From:
Sent: 12 March 2026 18:12
To: Jennifer Booth; DC Admin
Subject: Objection to planning application PP-14717946- 2026/90484

Application PP-14717946
Site Address: 143 Church Lane, Gomersal, Cleckheaton, BD19 4QN

I write to formally object to the above planning application relating to the extension, refurbishment and change of use of 143 Church Lane from a dwellinghouse to a Use Class C2 residential institution accommodating up to four children. While the reuse of vacant buildings can be beneficial in principle, I have significant concerns regarding the accuracy of the information submitted within the application and the potential impacts of the proposal on the surrounding residential area. I respectfully request that the Local Planning Authority carefully review the following issues before determining the application.

## Proposed Plans & Elevations

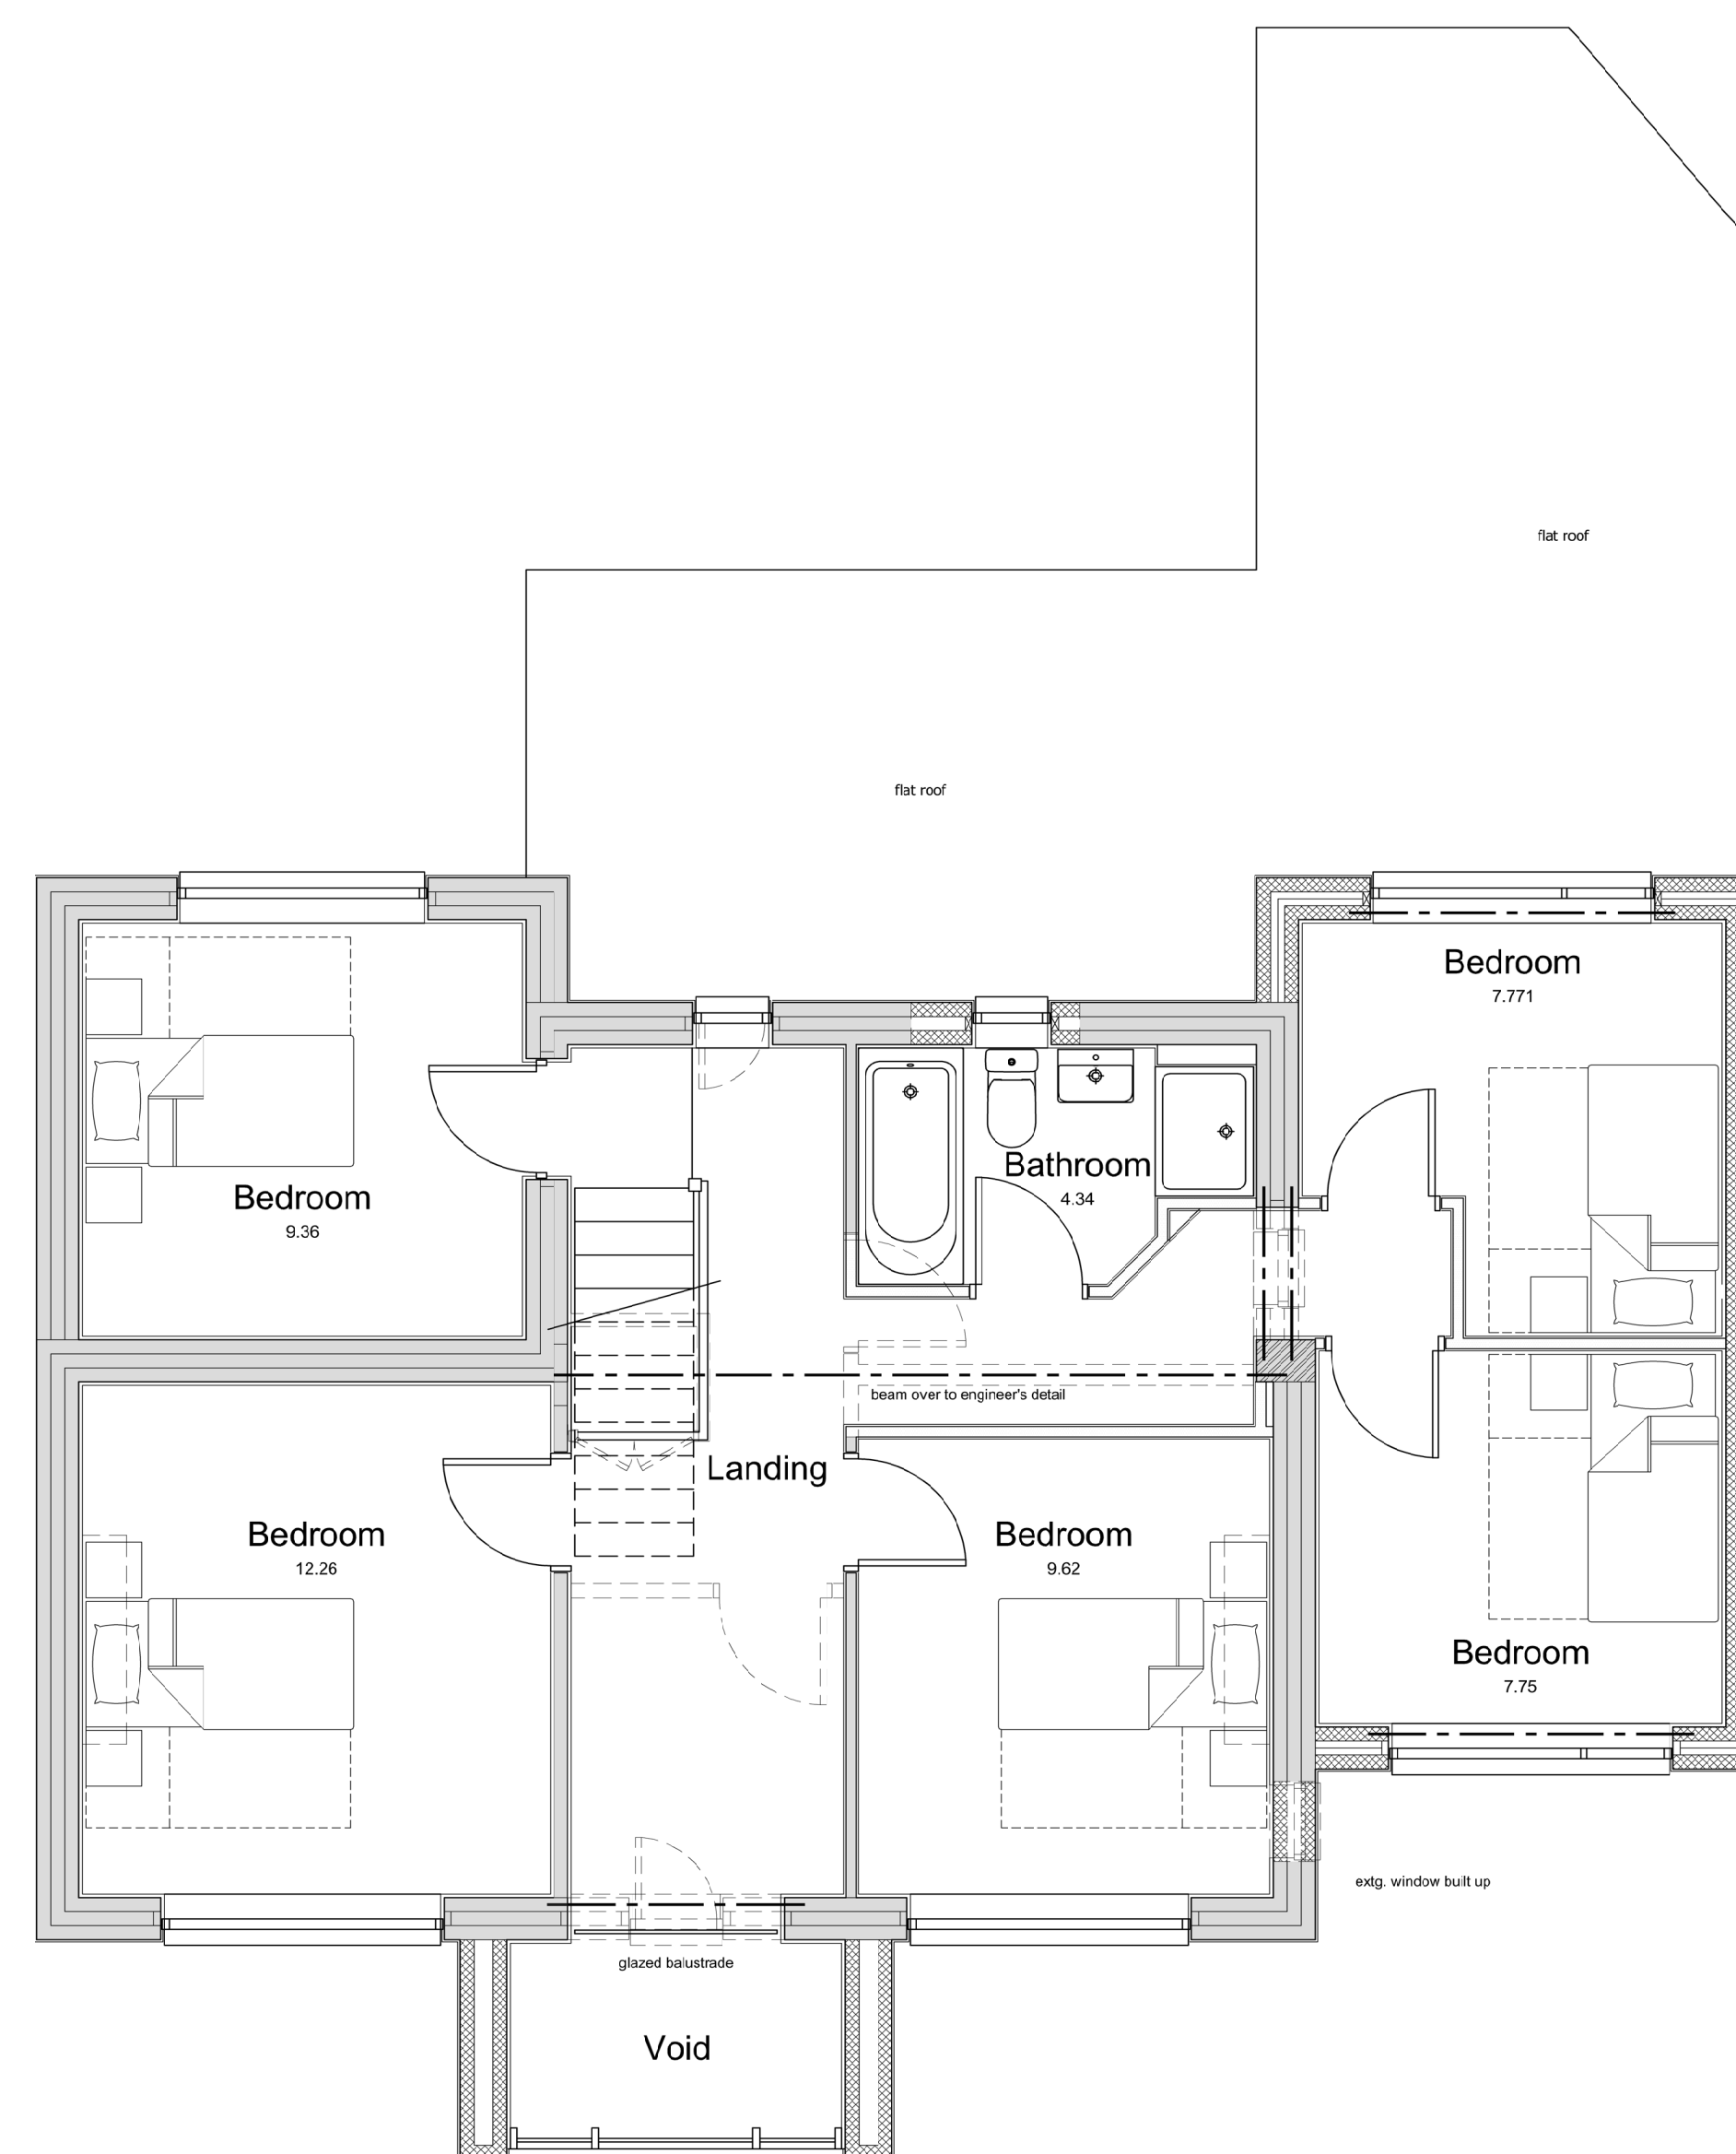
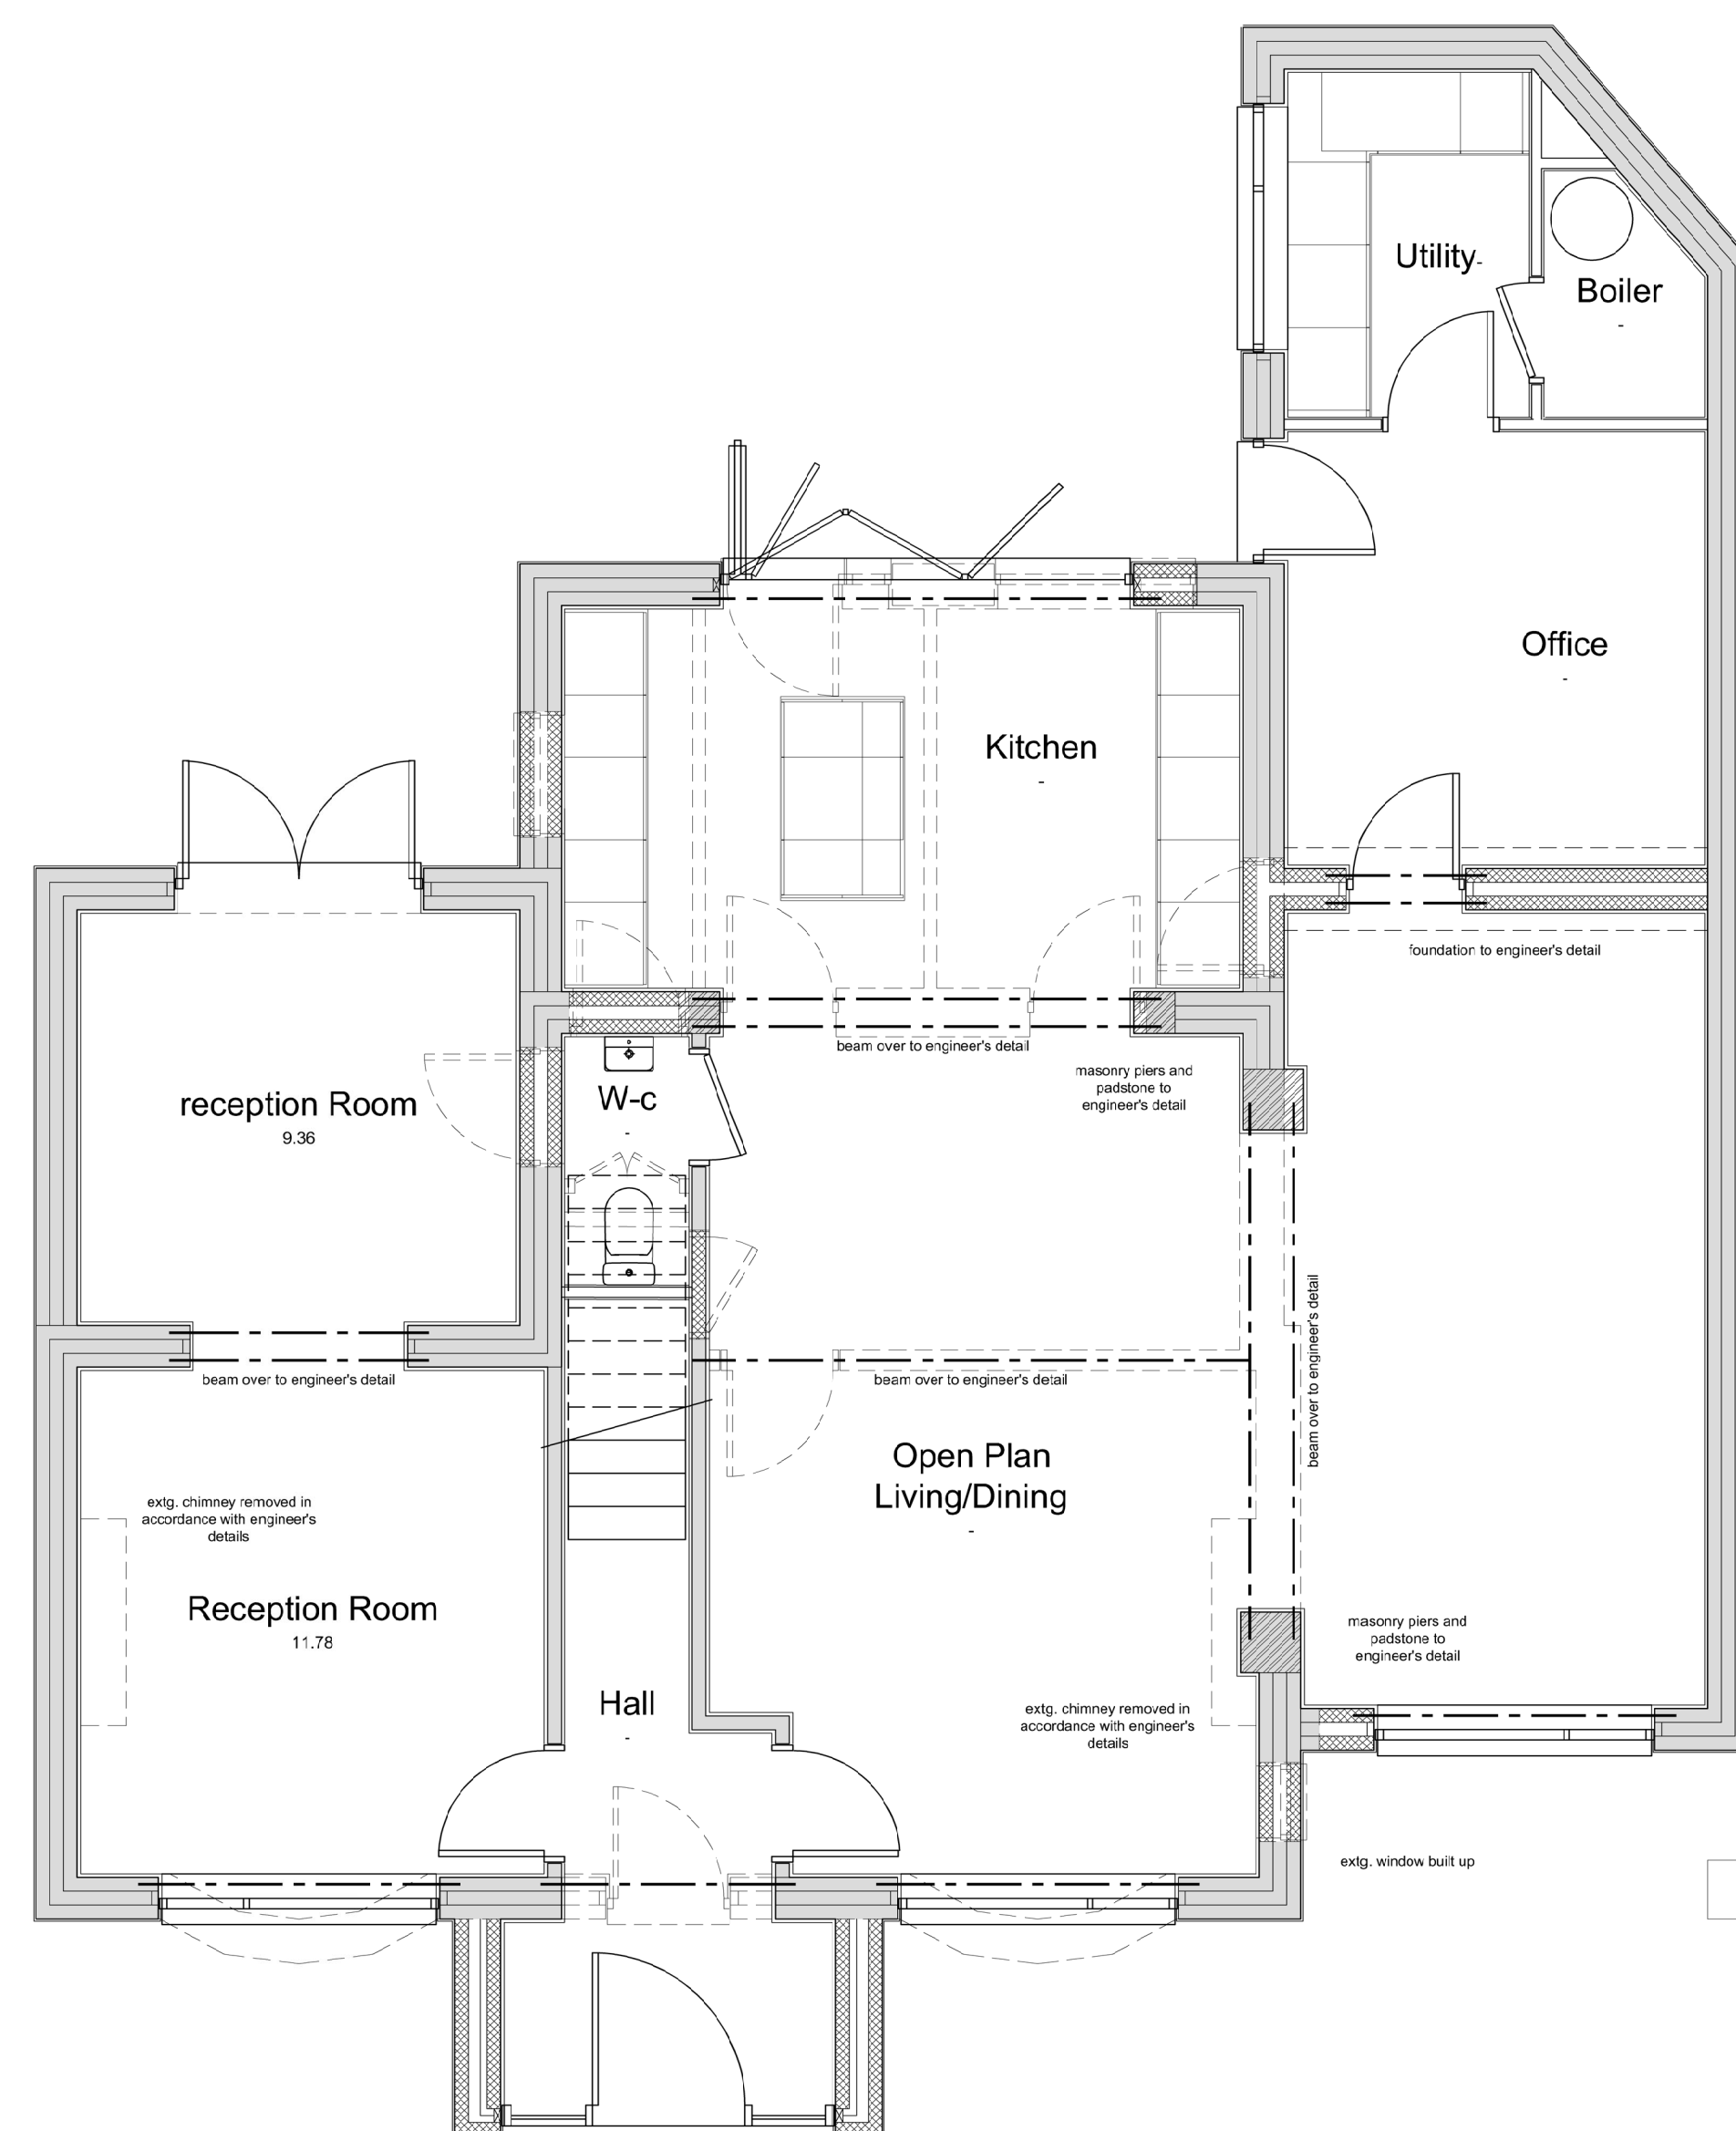
Thirdly, the proposal seeks permission for a residential institution accommodating up to four children, yet the submitted documentation refers to only two rooms associated with the residential use. This raises questions regarding whether the internal layout and accommodation are adequate to support the level of occupancy proposed. The Local Planning Authority should therefore ensure that the submitted plans clearly demonstrate that sufficient accommodation and facilities are provided in order to safely and appropriately support the proposed use.
